City of Albuquerque Stormwater Construction Site Inspection Report

ESC File No.	Q16E5000D	Project Name:	Kairos Power Phase 3		
NPDES Id. No.	NMR10069Y	Location:	5201 Hawking Dr SE		
2/2/2026	Owner		Contractor		
Operator	Kairos Power		Kairos Power		
Contact name & title	Mike Laufer		Rhonda Reynolds		
e-mail	laufer@kairospower.com		reynolds@kairospower.com		
Contact Phone #	510-808-5262		505-379-7175		
COA Inspector	James Hughes		Start/End Time:	2-4pm	
Construction Phase:	grading not complete, utilities not started, working on foundations				
Type of Inspection:	<input checked="" type="checkbox"/> Regular	<input type="checkbox"/> Storm Event	<input type="checkbox"/> Post Storm Event >0.25"	<input type="checkbox"/> 311/Complaint	<input type="checkbox"/> Follow Up
Weather at time of inspection?	cloudy		Temperature: ~	50	
Estimated date of last storm 0.25" or greater	1/29/2026

Notes: This inspection focused on the missing berm and out-of-date SWPPP.

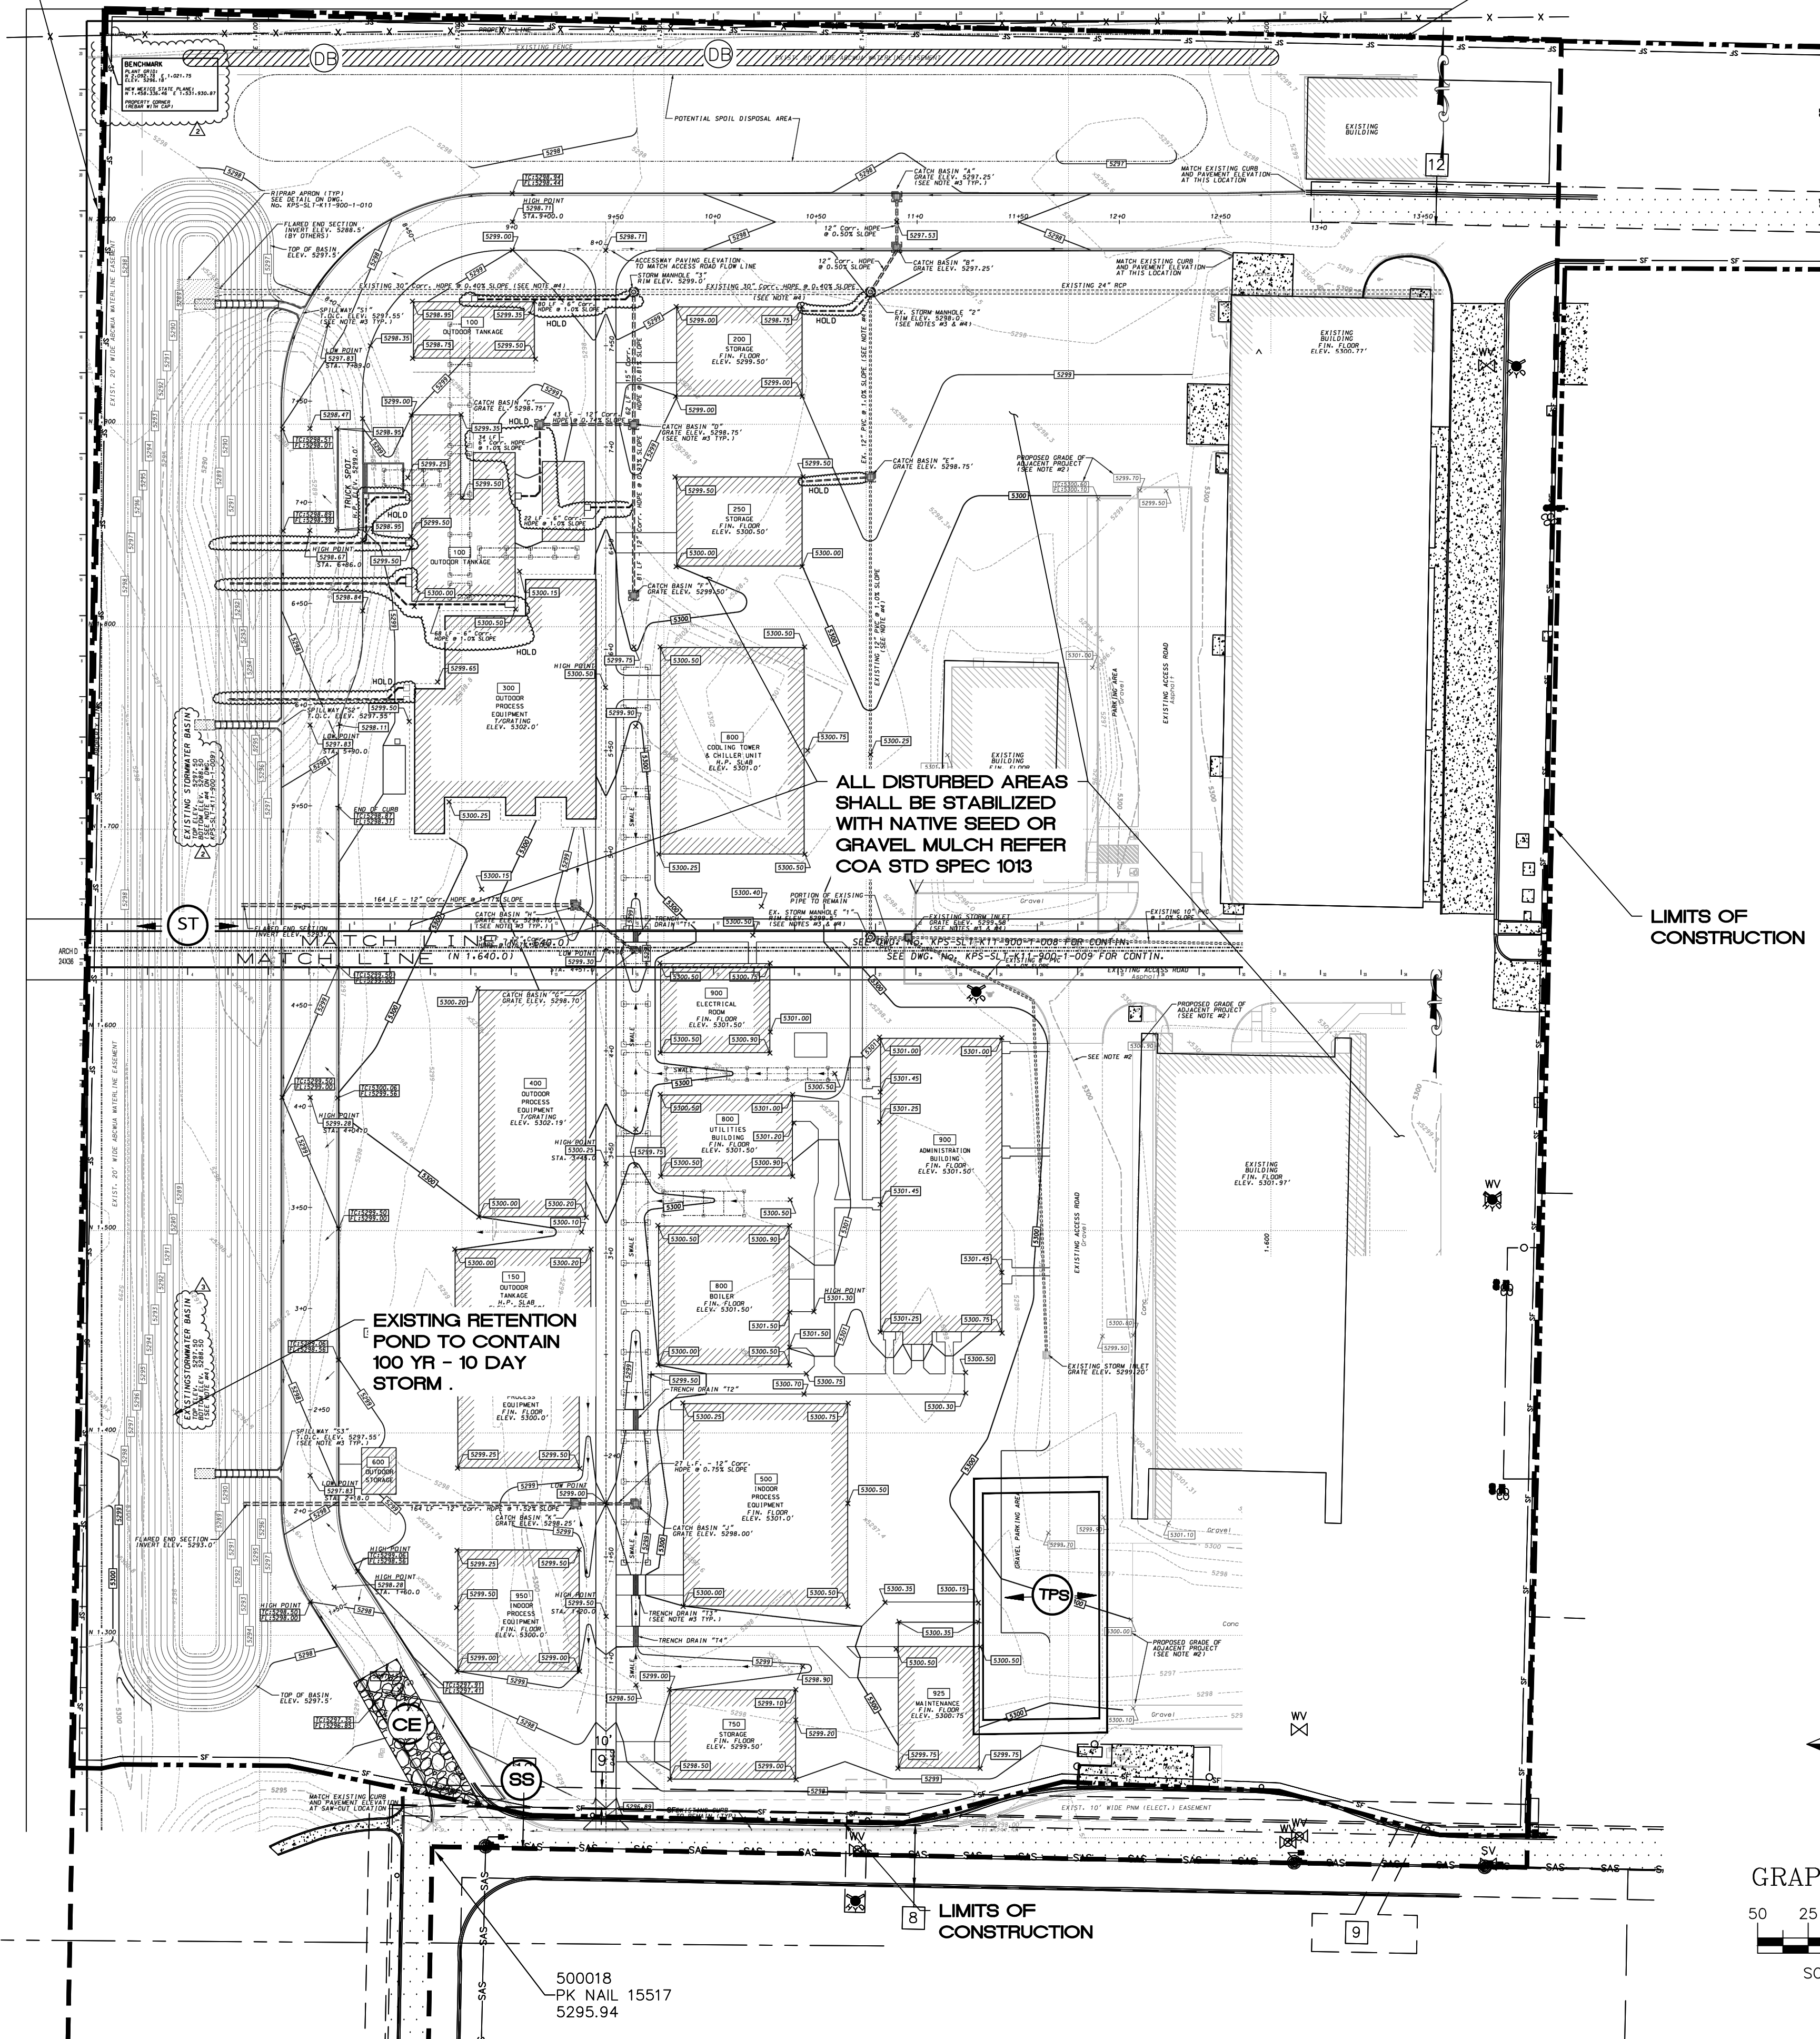
2	<p>BMPs were not installed, which is a serious violation of CGP 2.1. Specifically, the north berm required by the city-approved ESC Plan, with the engineer's stamp dated 5/19/2025, was missing. A large pond on the west side of Kairos Power's site has served as Kairos Power's primary BMP since the beginning of their permit coverage in 2020, but the latest phase of construction activities disrupted the drainage pattern, creating a ridge between the site and the pond. Currently, a large portion of the drainage from Kairos Power's site has been diverted north by the earthwork, so the north side is now downgradient of the construction activities and lacks adequate BMPs. Required mitigation: If at any time you find that a stormwater control requires routine maintenance, you must promptly initiate the necessary repairs and complete them by the close of the next business day. Construction of the missing berm or other controls approved by the city is a corrective action and must be finished in accordance with CGP Part 5. The approved BMP must be installed and operational within seven (7) calendar days from the time of discovery, as specified in CGP 5.2.1.</p>

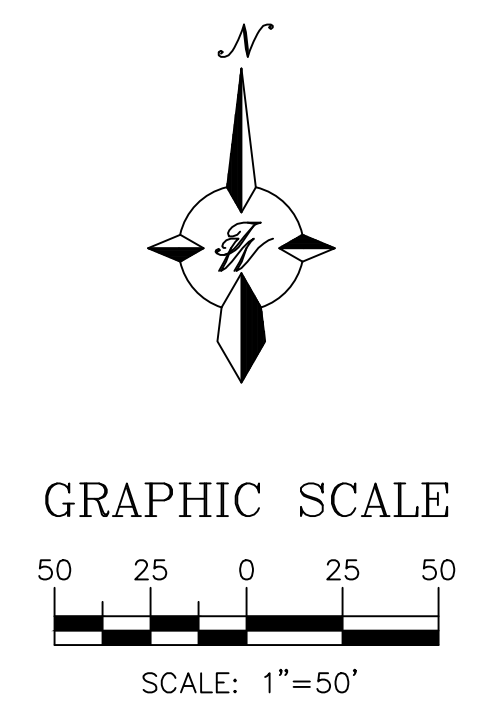
Item Number	Deficiency/ Corrective Action				
1	<p>SWPPP - The SWPPP wasn't "up-to-date" in violation of CGP 7.1.</p> <p>1. The individuals responsible for the Kairos Power Storm Water team are not identified in the SWPPP, which violates CGP 6.1. Specifically: a) Ron Bohannon, PE of Tierra West, appears to be in charge of designing the stormwater control best management practices (BMPs), but his name and contact information are missing from the SWPPP; b) The SWPPP does not list the persons responsible for maintaining or repairing stormwater controls; c) The SWPPP fails to identify personnel responsible for applying and storing treatment chemicals; d) Diane Moore from Inspections Plus has been signing the self-inspection reports, but her role as the person responsible for inspections is not specified; e) The SWPPP does not specify who is responsible for taking corrective actions, as required in Part 5 of the CGP.</p> <p>2. Kairos Power failed to put the approved ESC Plan (aka SWPPP Map) in its SWPPP in violation of CGP 7.2.4. Luis Noriega and Tiara West developed Kairos Power's SWPPP and designed the Stormwater Control Best Management Practices (BMPs) on Kairos Power's ESC Plan, but didn't put the approved ESC Plan in Kairos Power's SWPPP. The map in the SWPPP was dated 2/2/2025, but the approved ESC Plan has an engineer's stamp date of 5/19/2025.</p> <p>3. Kairos Power failed to update the "Operator Point of Contact" on its NOI. Kairos Power's official point of contact, Lara Gutierrez, said she is no longer the point of contact and has repeatedly redirected incoming calls to fellow employees and to third-party consultants.</p> <p>4. A written delegation of Michael Laufer's signature authority to Rhonda Reynolds was missing from the SWPPP. Rhonda Reynolds signed the certification statements on the SWPPP and Self Inspection reports on behalf of Kairos Power without establishing a written delegation of Michael Laufer's signature authority in the SWPPP, which violates Appendix G11.2 of the CGP. Required Mitigation: The SWPPP, including the SWPPP Map, Self Inspection Reports, and Corrective Action Reports, must be kept up-to-date per CGP 7.1 and available on-site per CGP 4.7.3, 5.4.3, and 7.3. If an on-site location is unavailable to keep the SWPPP when no personnel are present, notice of the plan's location must be posted near the main entrance of your construction site. <i>CGP 7.3</i></p>
